From: Robert Findlay
Sent: 04 June 2014 14:40
To: Planning.Responses
Subject: FW: C203794 - BR/124/14/PD

I haven't been given the original e-mail for this, just the complaint number. Change of use from offices to dwellings. Can you reply with your comments?

Project:-			
Proposed Residential Development 72 Aldwick Road Bognor Regis West Sussex			
Title:-			
Proposed Floor Plans			
Client:-			
Mr Peter Fullegar			
Scale:-			
1:50 (@A1)			
Drawn By:-	PJD	Checked By:-	
Date:-	18/04/14	Date:-	
Job.No:-	120039	Drg.No:-	04
		Rev:-

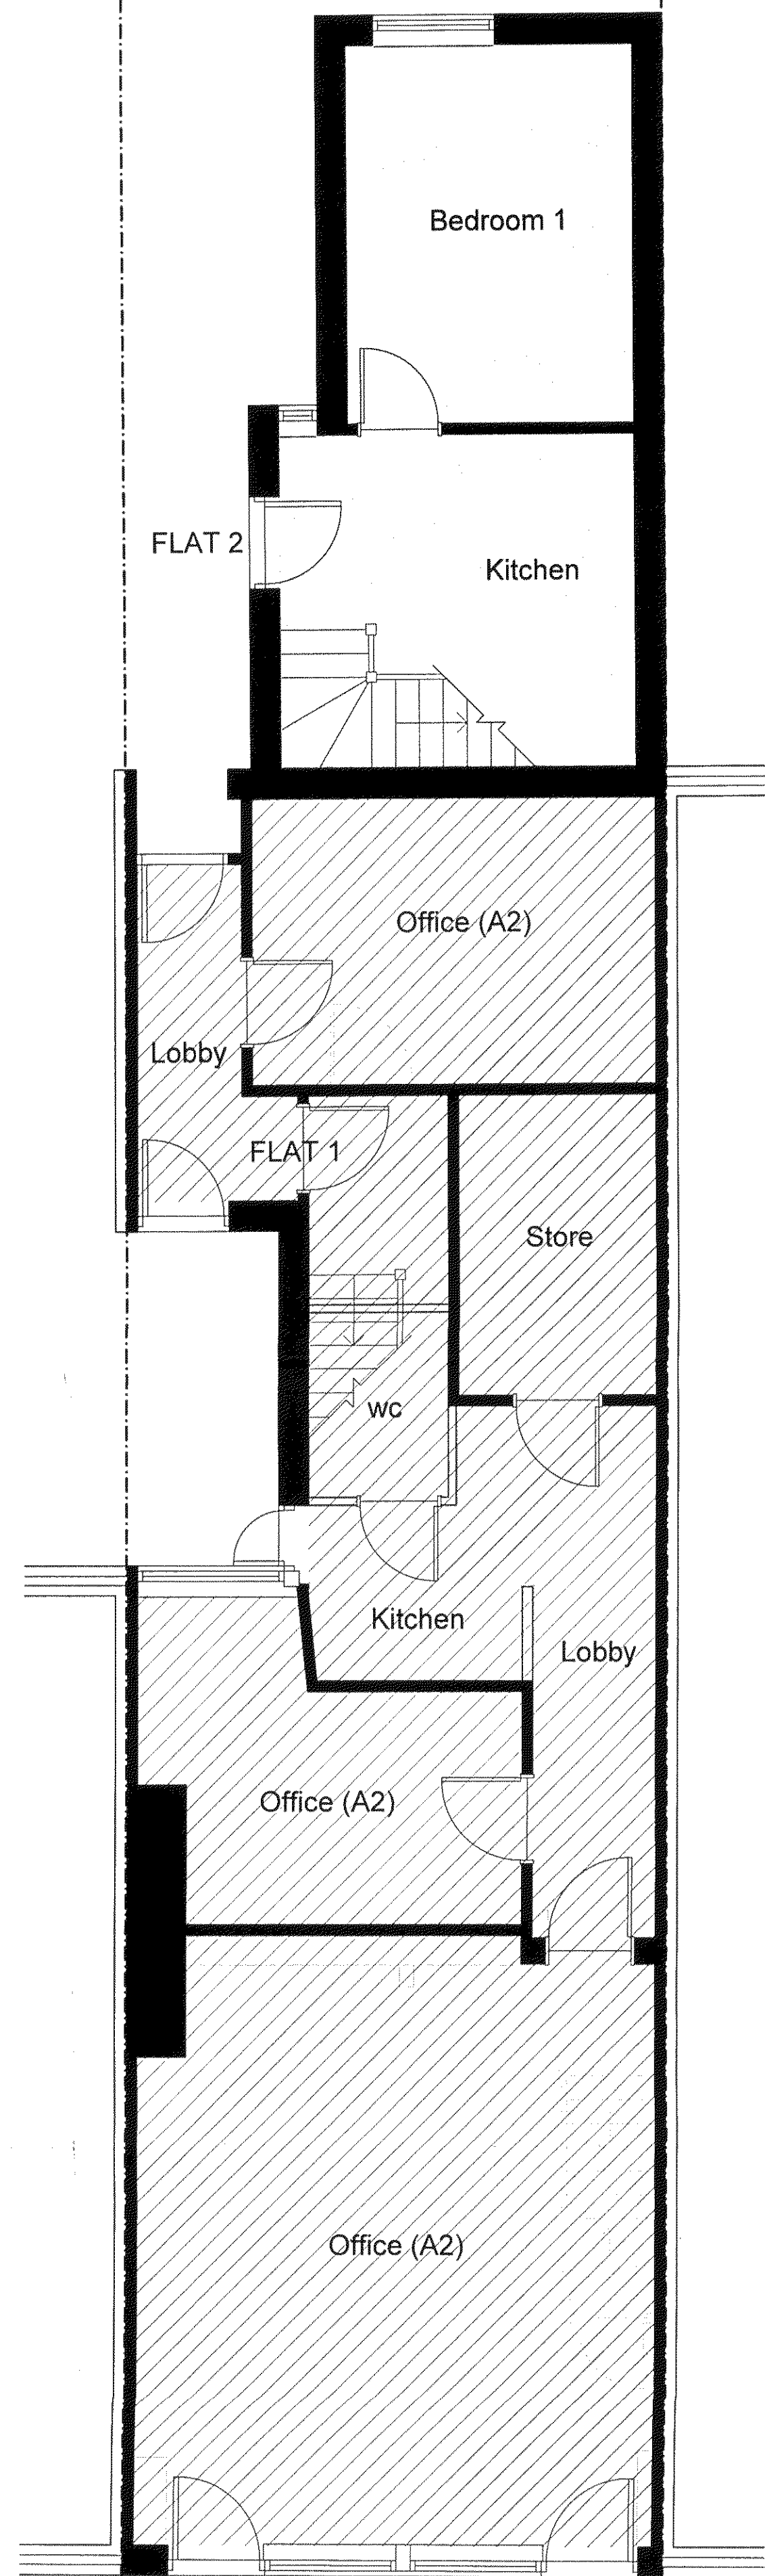
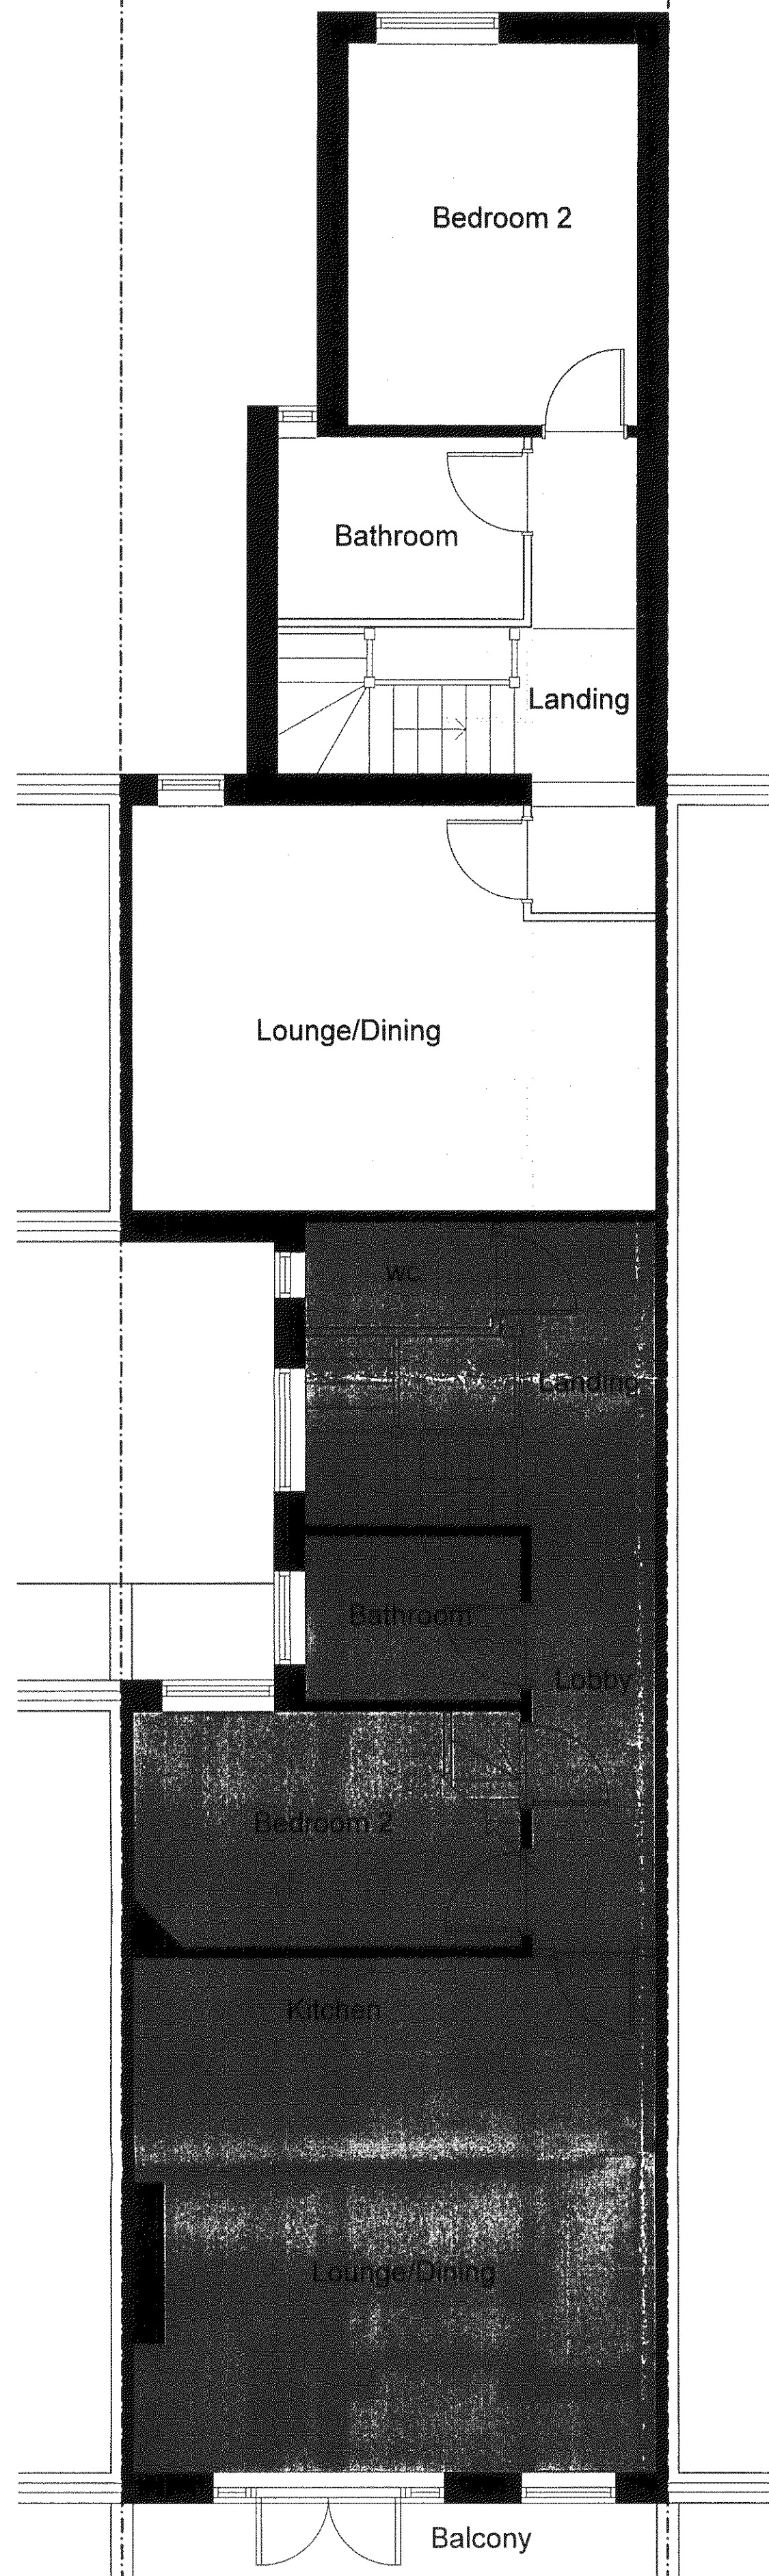
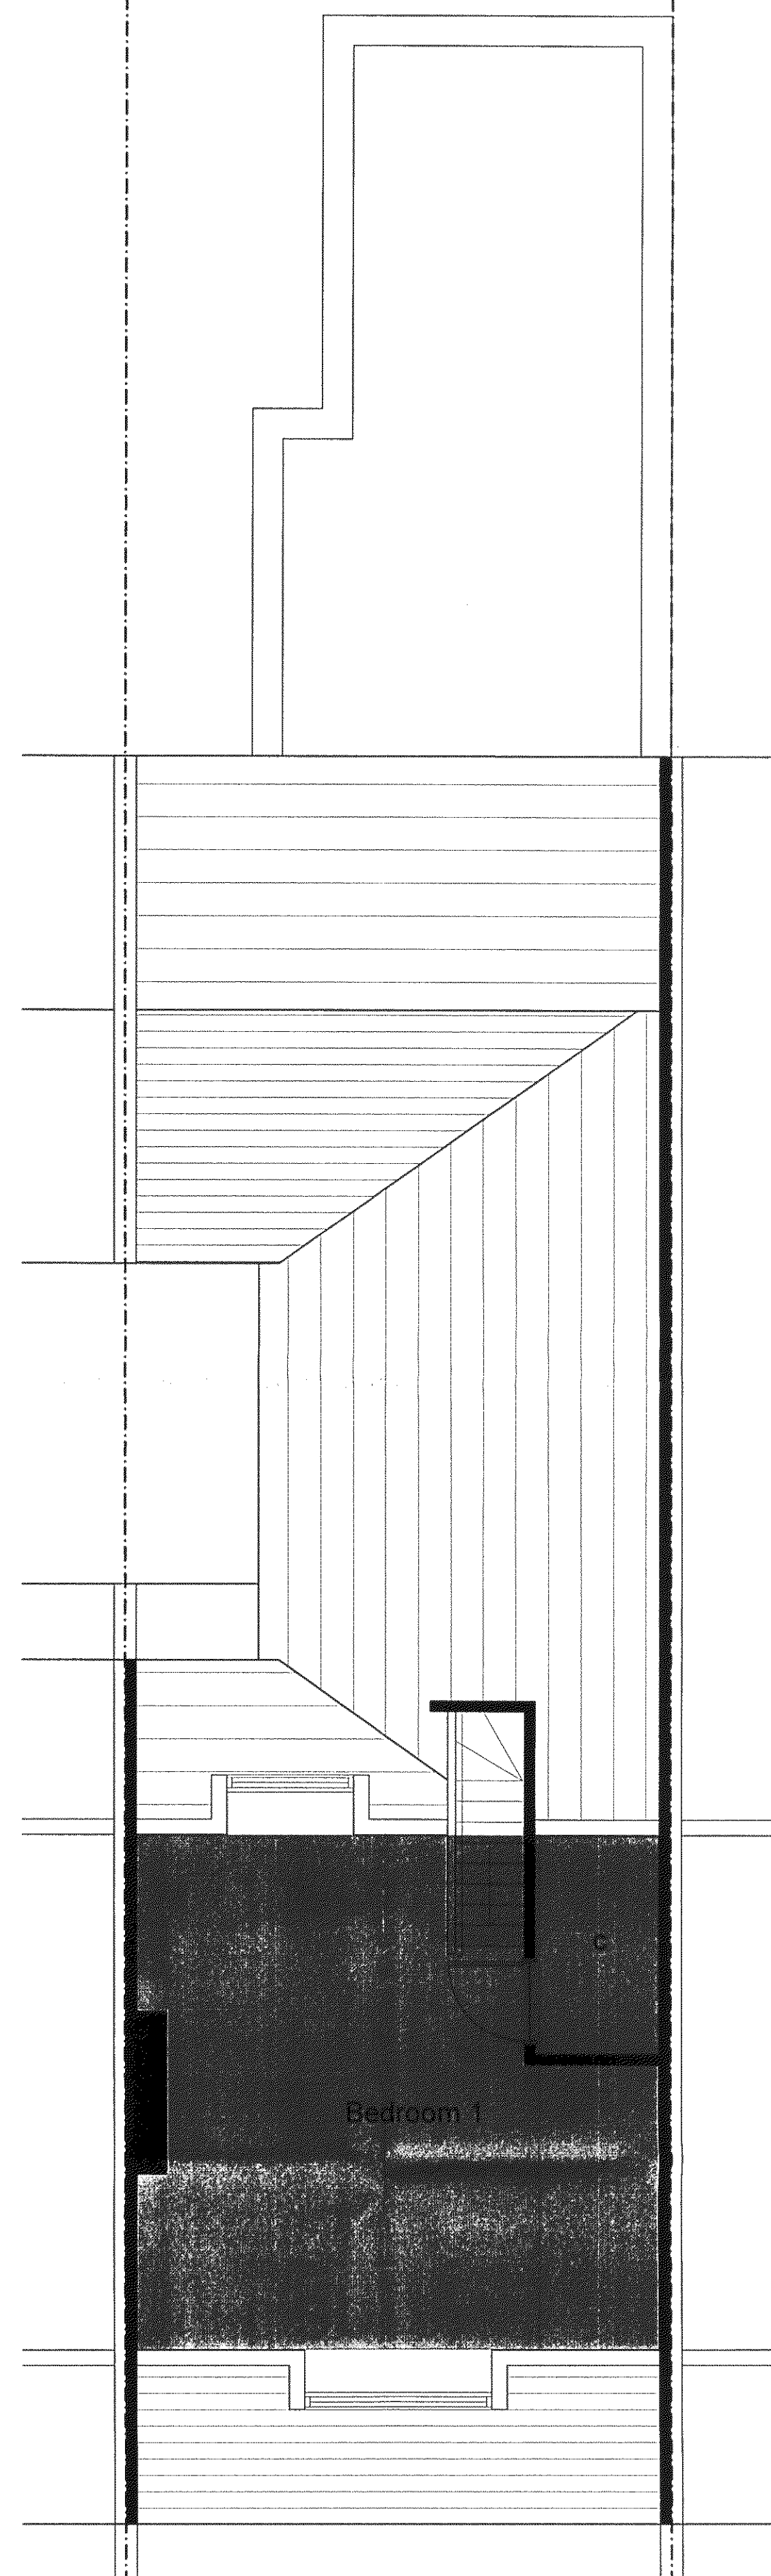
I cannot comment regarding the proposals for flat 1 as the plans are not clear for this development.

No objections to flat 2 other than means of escape from the bedrooms is via another room of significant risk, unless means of escape windows are provided to escape from the bedrooms in the event of a fire.
